SSD modification no. 7 application to Sydney Football Stadium Precinct Village and Car Park, SSD 9835

Thank you for your referral dated 26 October 2021 inviting comments from the Heritage Council of NSW on the above State Significant Development (SSD) proposal.

Steven Meredith
 Director
 Heritage Programs
 Heritage NSW
 Department of Premier and Cabinet
As Delegate of the Heritage Council of NSW
 23 November 2021

Figure 9: Busby's Bore local detail - Sydney Water plans

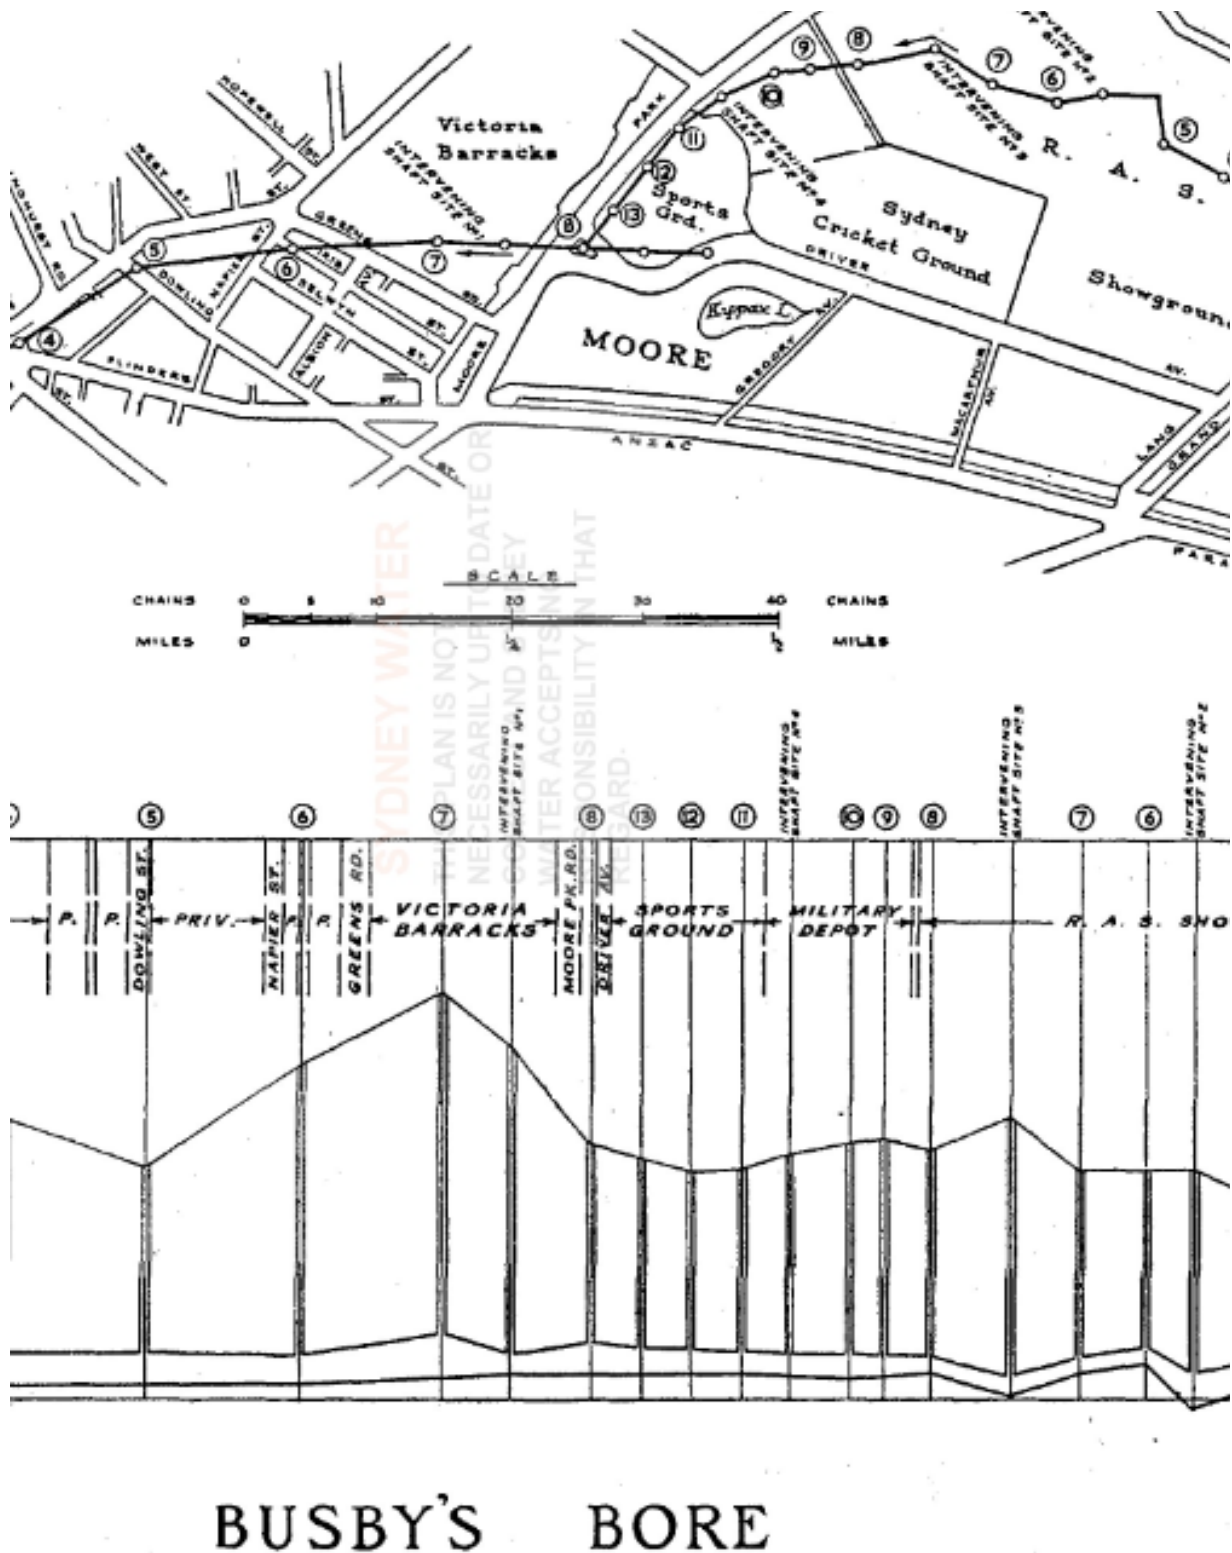
- HNSW recommends that the vibration monitoring assessment of Busby's Bore considers:
 - Physical access shafts/points to the Bore should be confirmed, which could be used to place the vibration monitor(s). For example, the HIS refers to Shafts 9–13 within the vicinity of the site and notes that Sydney Water plans indicate that two shafts are located on the spur beneath the site etc (p. 21–22).

Figure 27: Arup projection of Busby's Bore levels (red) relative to maximum proposed development depth

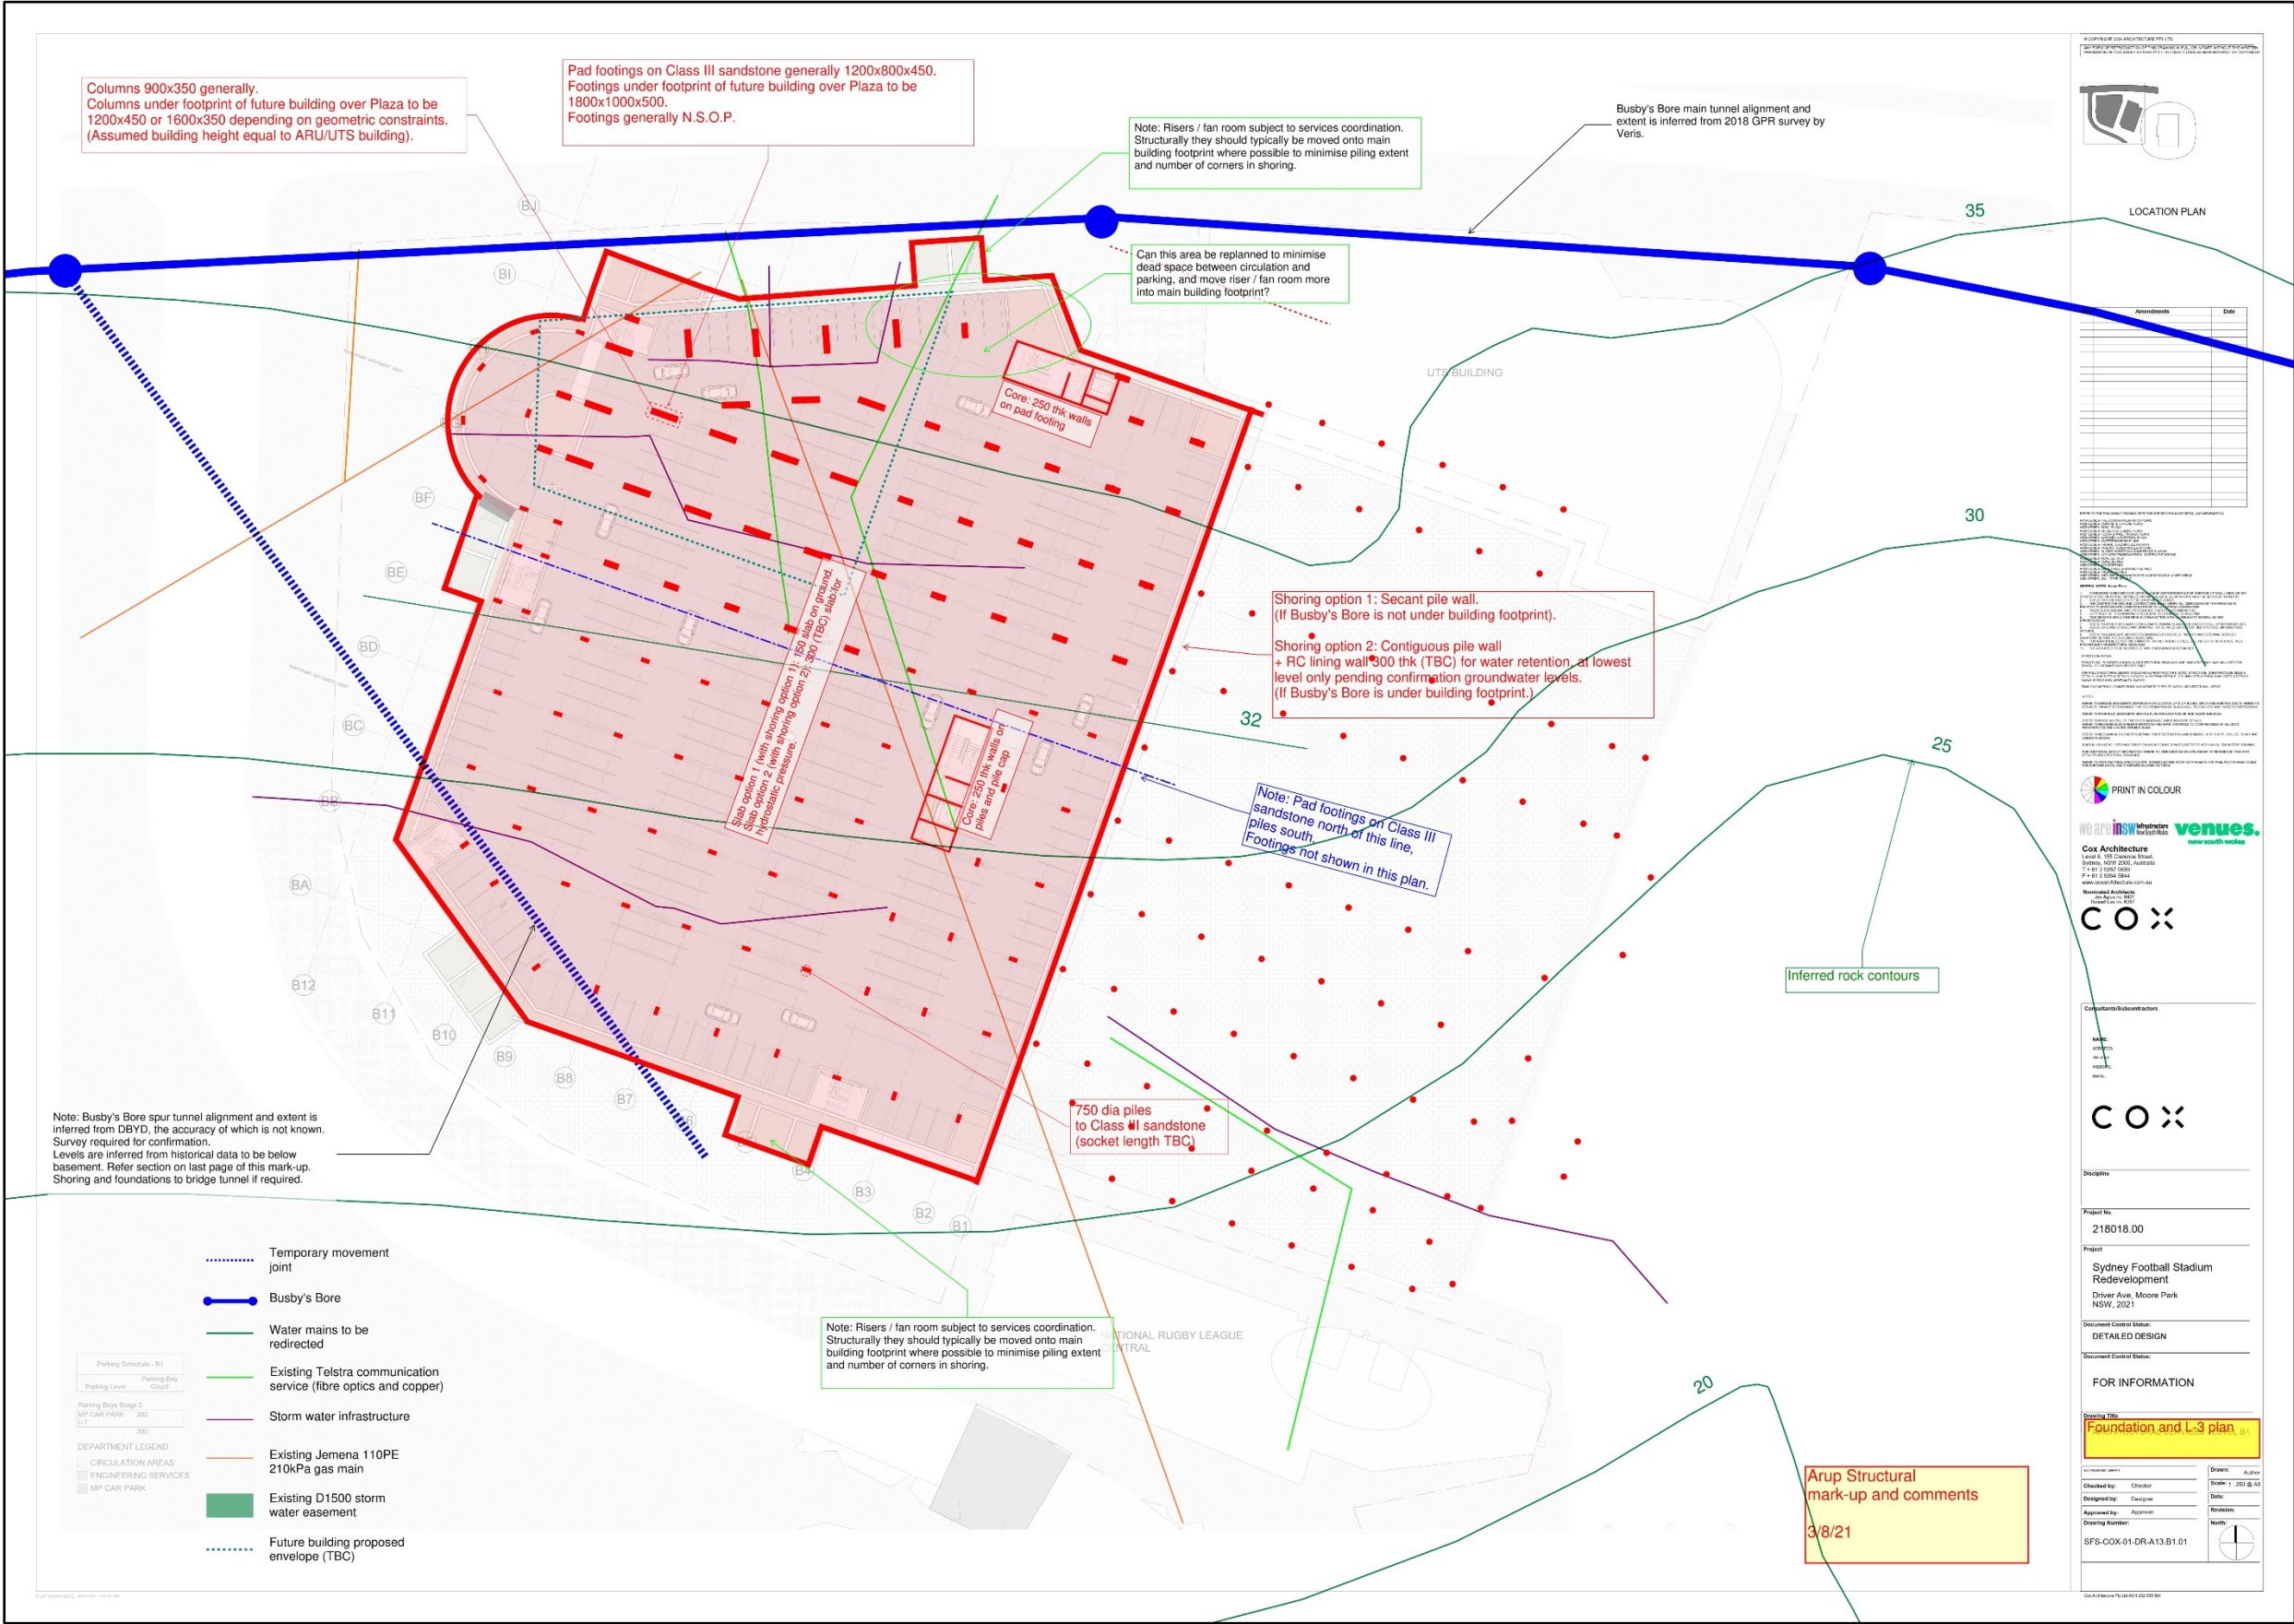
- If a new structure(s) is to be built directly over Busby's Bore or within its curtilage, then further design/engineering details depicting how these works and the carpark basement would interact with Busby's Bore, any Bore shaft(s) and the heritage curtilage would be beneficial, in order to demonstrate any (potential) heritage impacts on the item.

- The HIS assesses that (the fabric of) Busby's Bore would not be impacted by the proposal and that "if the spur or shafts are unexpectedly found to be within the study area redesign would be required" (p. v, 59). It is unclear to HNSW how feasible redesign is considered for the development at this stage. The HIS further states that "detailed construction and excavation plans are not yet to hand" (p. 47). This is a circumstance that could result in unanticipated impacts to Busby's Bore and/or the heritage curtilage.
